Application number: 2024/91754	
What is the application for?:	Erection of single storey rear extension, partial demolition of existing rear
Address of the site or building:	14, Manor Road, Farnley Tyas, Huddersfield, HD4 6UL
Postcode:	HD4 6UL

Type of comment: An objection	
Do you wish your comments to be published on the website anonymously?	Yes

SECTION A-A AS PROPOSED
 Scale 1:100
 Drawing XP/6

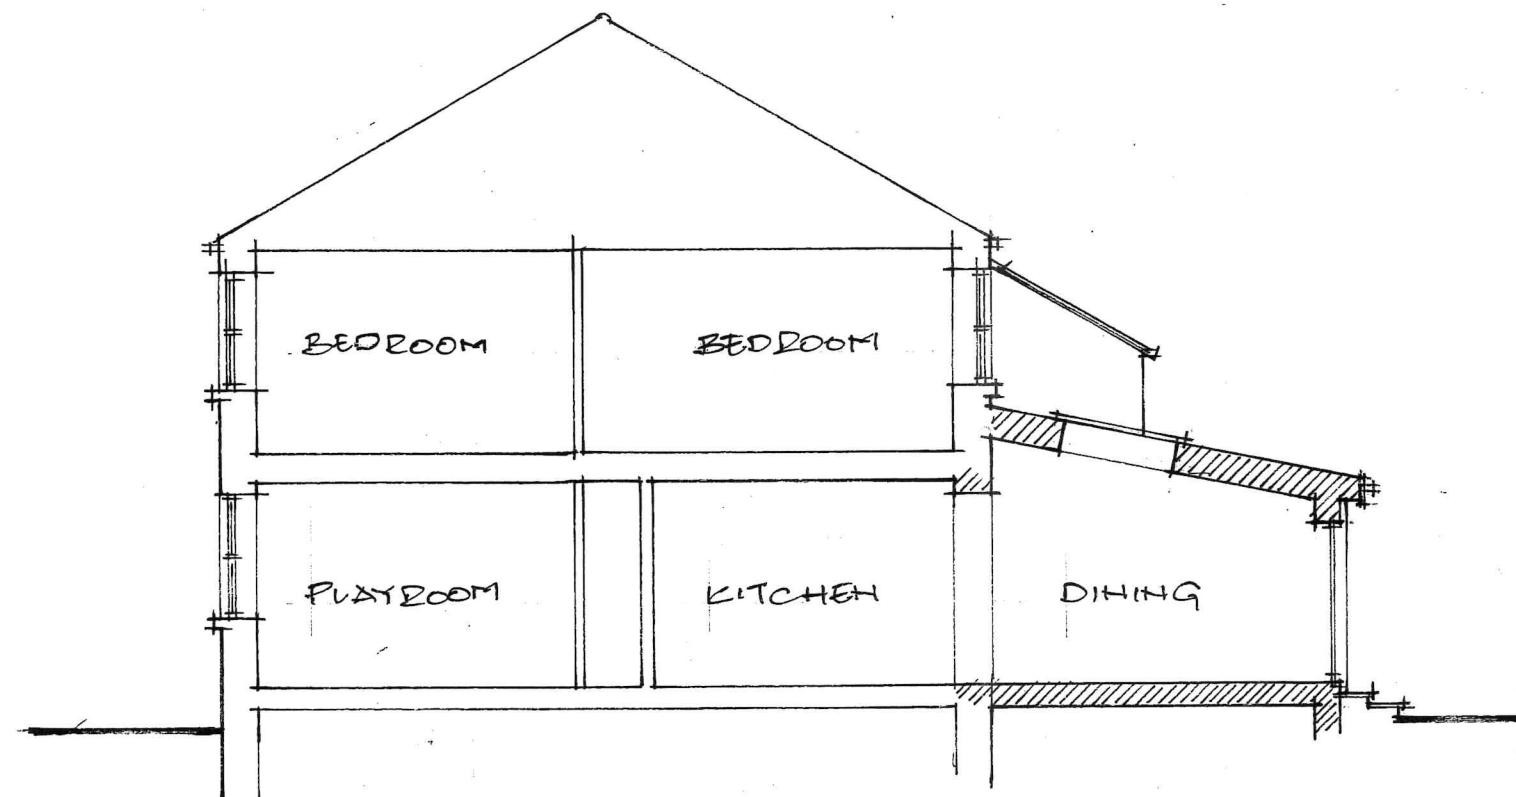
The proposed plans include demolition of the shared stone boundary wall between the properties and the building of an extension up to the boundary line, extending 4.7 metres back from the existing rear elevation.

The centre of lounge window is positioned 2 metres from the boundary line. We believe that by building right up to the boundary between the properties, the extension will block light entering lounge and contribute to it being excessively dark. Contrary to the planning application (supporting information 1046986) the “evergreen shrub screening” described on side of the boundary wall consists of 3 deciduous Salix Caprea trees which lose their leaves in Winter, allowing significant light into lounge.

At the current dimensions, the planned extension extends well beyond the 45 degree angle usually permitted to prevent loss of light and overshadowing of adjacent properties. We feel that if the building extends to the boundary line it will negatively impact on the outlook from lounge and lead to overshadowing of lounge and outside patio area.

ROOF PLAN AS PROPOSED
Scale 1:100
Drawing #P/2

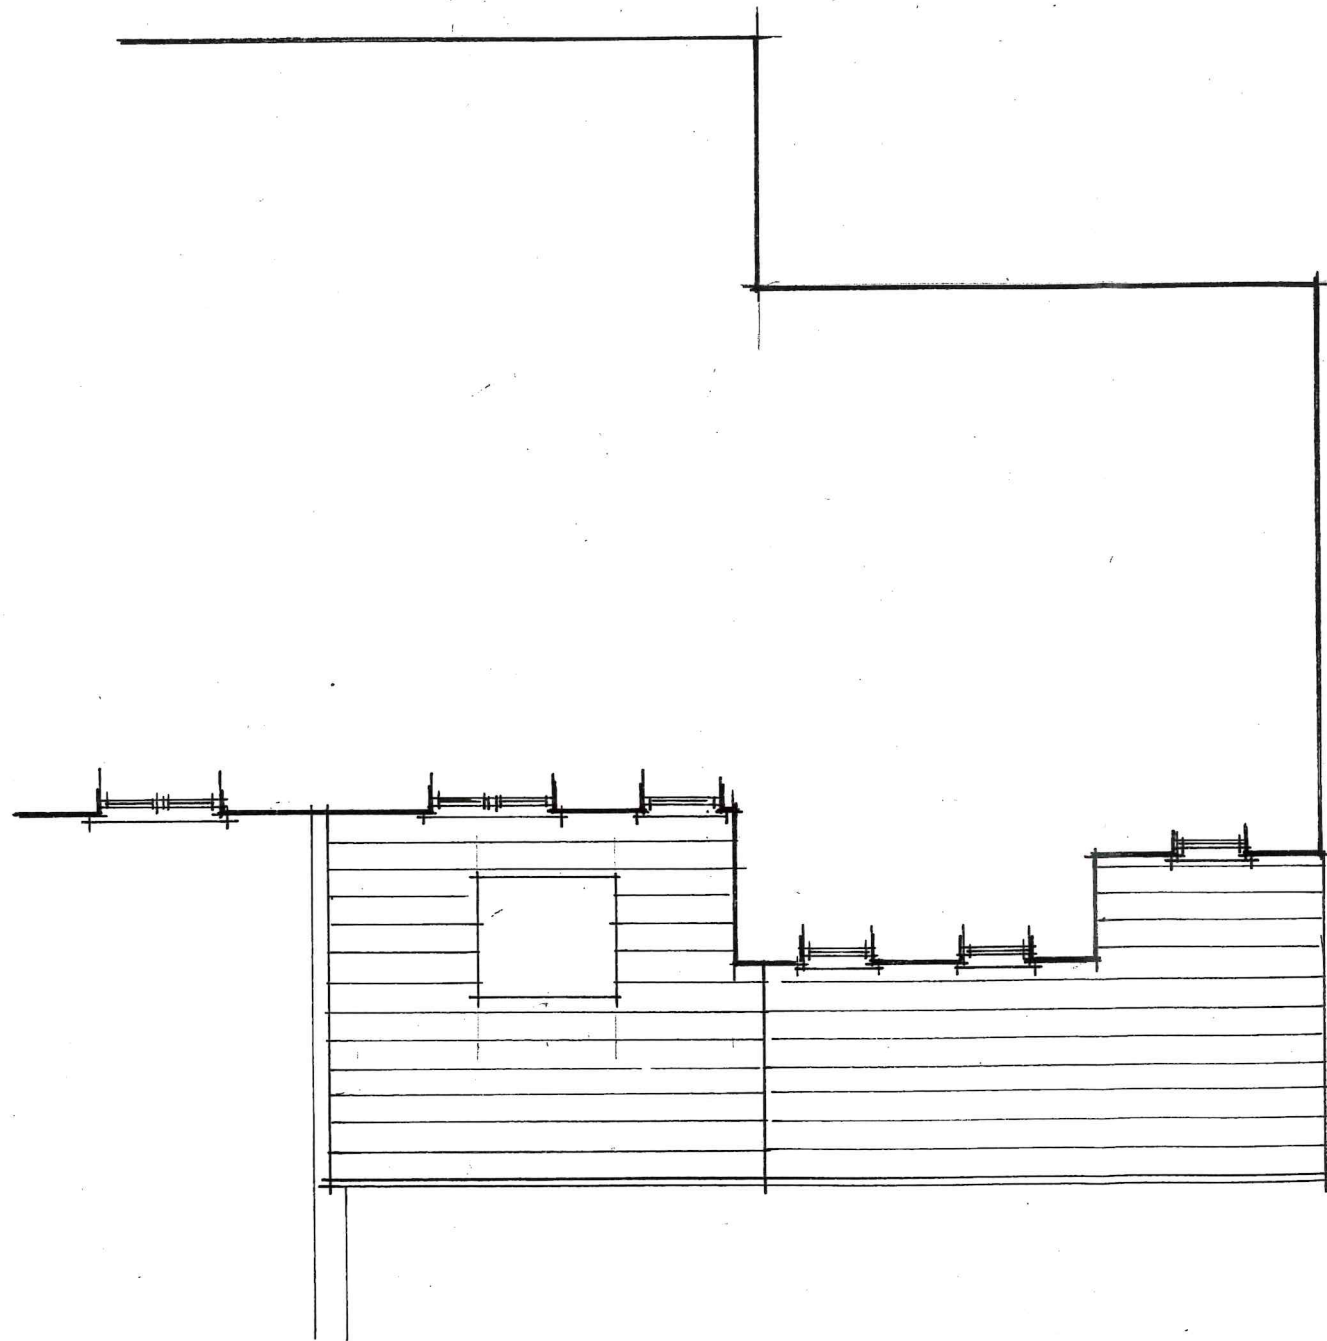
- Not project out more than 3 metres from the rear wall of the original house
- Retain a gap of at least 1 metre from a property boundary such as a wall, fence or hedge

At the proposed size and position, the extension does not comply with any of these recommendations. We would therefore request that the plans are revised.
